**SOIL/SITE EVALUATION  
 for ON-SITE WASTEWATER SYSTEM**

Owner: *Southern Built* Applicant:  
 Address: *1062 Old US421*  
 Proposed Facility: *SFD*

Date Evaluated: *9-30-21*  
 Design Flow (.1949): *360 GPD*  
 Property Recorded:

LOT T-1A OLD US 421
SCALE 1" = 40'-0"

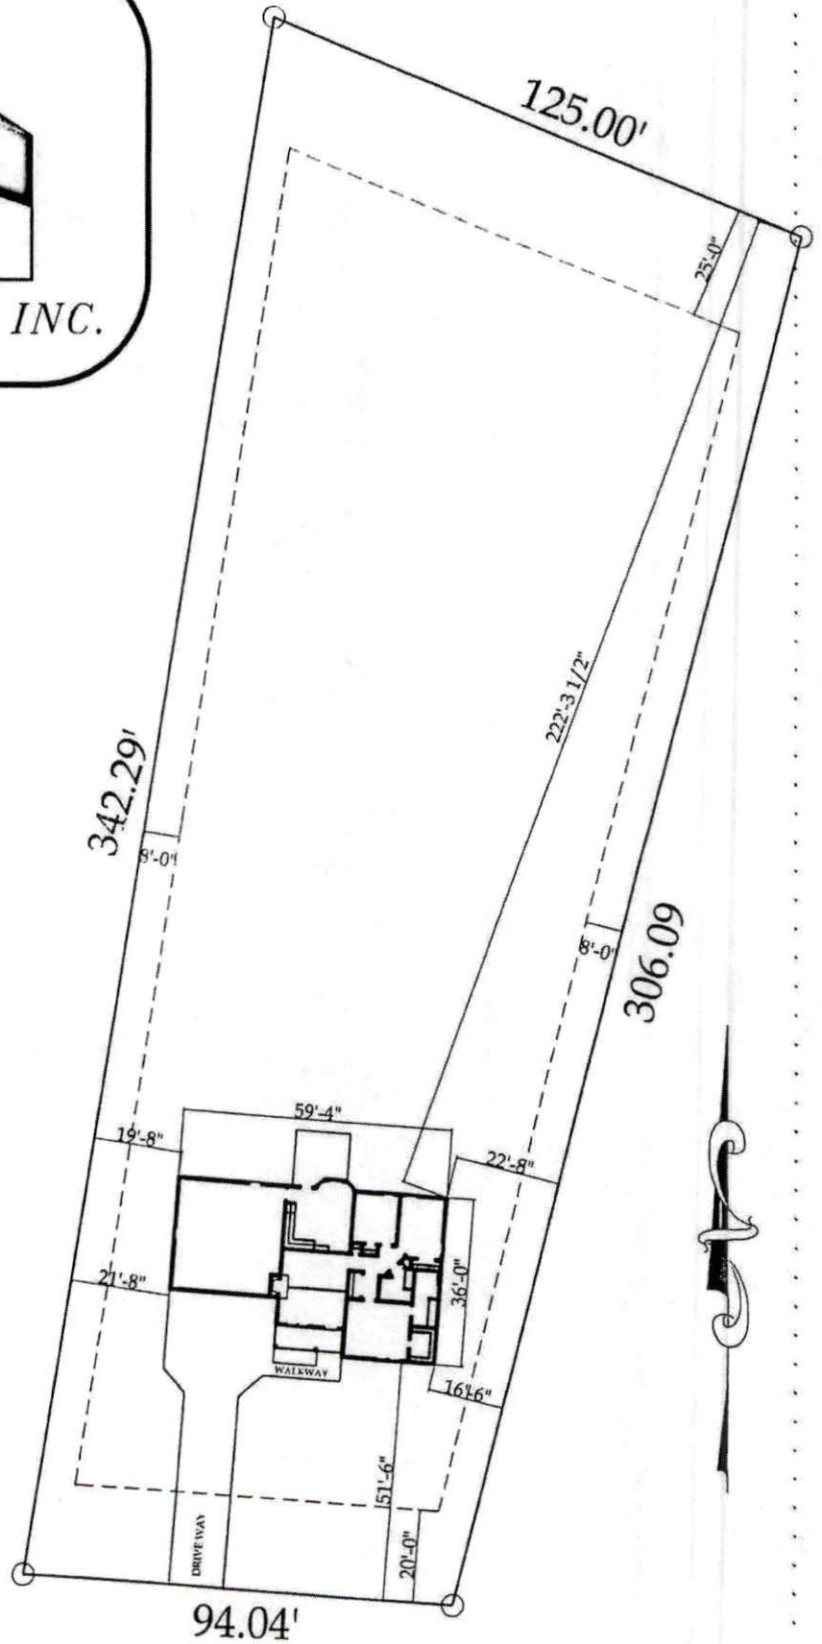
*9-30-21*  
*Need EROSION*  
*Need House Status*  
*Need Property Lines*
